Great Lakes UK Limited
Great Wolf Lodge, Chesterton, Bicester

Non Material Amendment (S.96a) Application
Design Changes

March 2023

This document has been prepared by EPR Architects in support of a Non Material Amendment (NMA) application associated with proposed changes to Applicant ref. 21/04158/F.

Proposed Ground Floor Plan Part 3

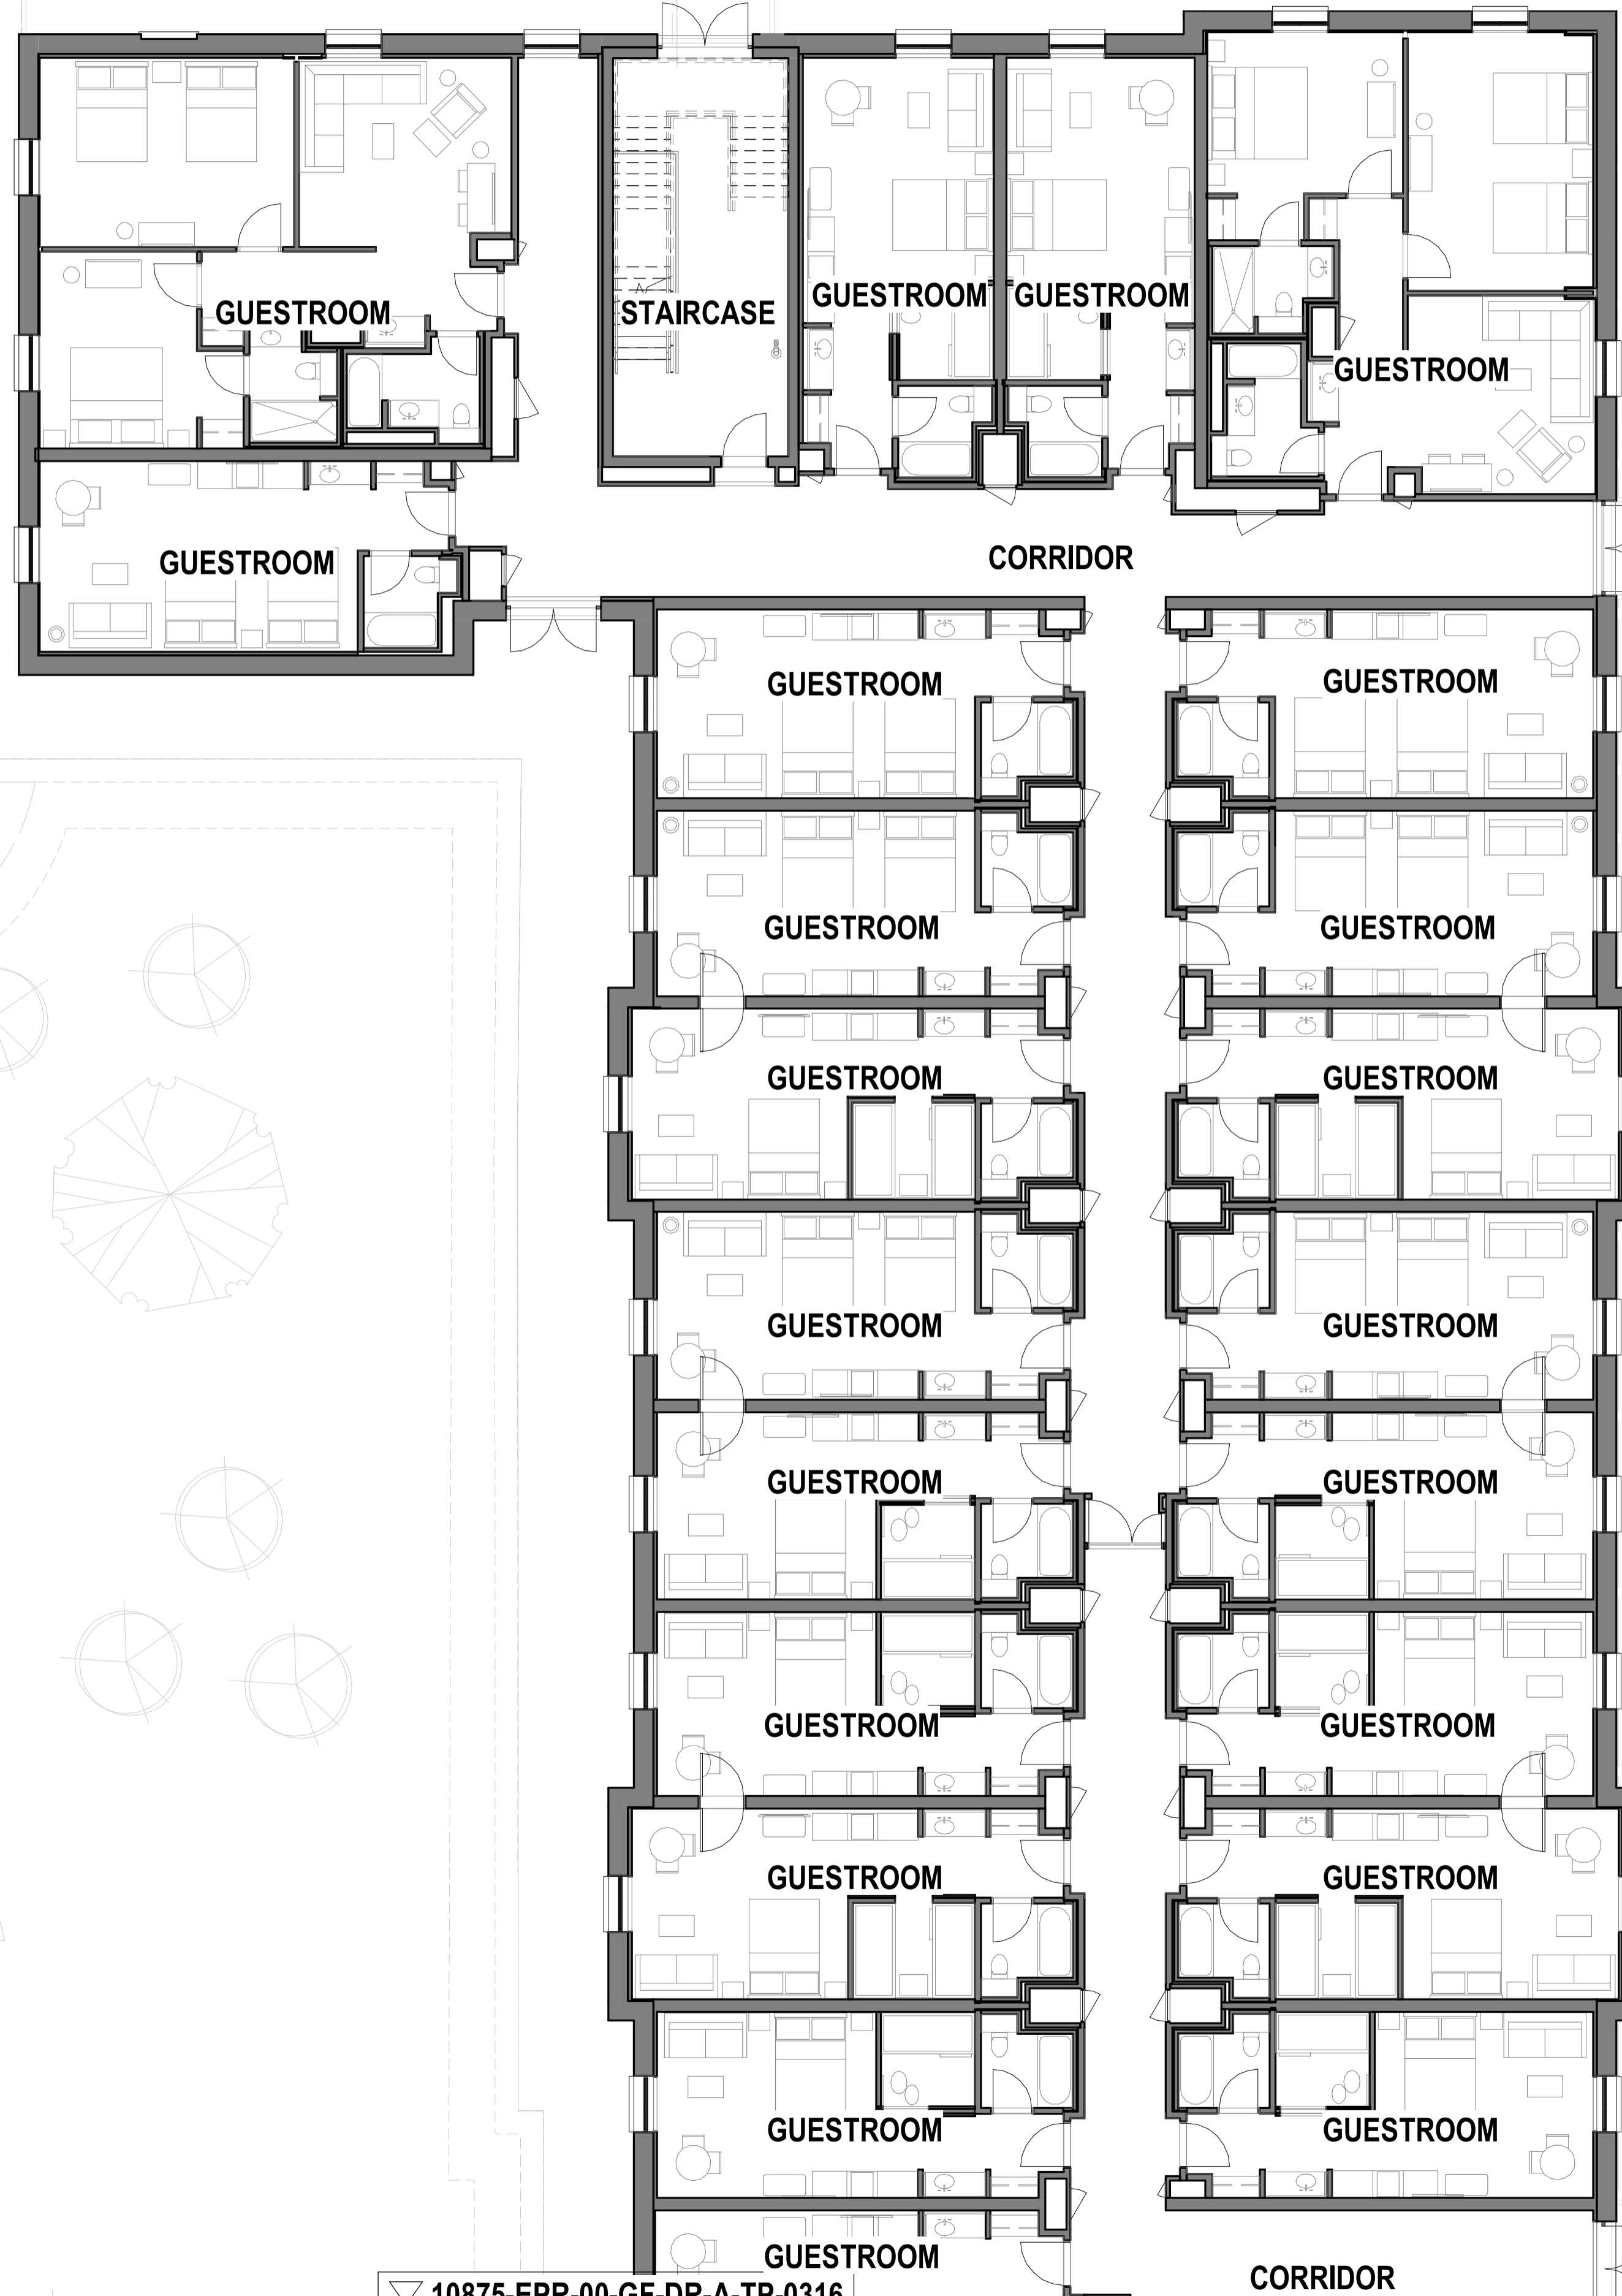
- ① Facades pushed out to allow columns not to protrude into guestrooms.
- ② Corner guestrooms changed to new enlarged types on every floor. 12 no. total rooms affected but no increase in room numbers with this change and no facade changes.

- ③ Updated materials on corner of building to enable better corner construction of materials and finishing. Render and brick now continues to building edge.

- ④ Door to ground floor added for fire escape.
- ⑤ Replace windows in corner rooms (where there were two windows in room) to recessed reveal detail.
- ⑥ Main BOH windows setting out change to suit internal layout changes.

- ⑦ Windows lowered around the Buckhorn and the BOH offices near the porte cochere.
- ⑧ Omission of the landscape storage unit and associated door. Omission of doors from wall facing service yard.

- ⑨ Changes to laundry strategy.
- ⑩ Changes to the landscape design.
 - 1. Access ramp to hot tub area omitted in lieu of platform lift
 - 2. Changes to access paths around the building perimeter

- 3. FEC amenity area changed from play space to seating areas
- ⑪ Omission of window to staff changing room.
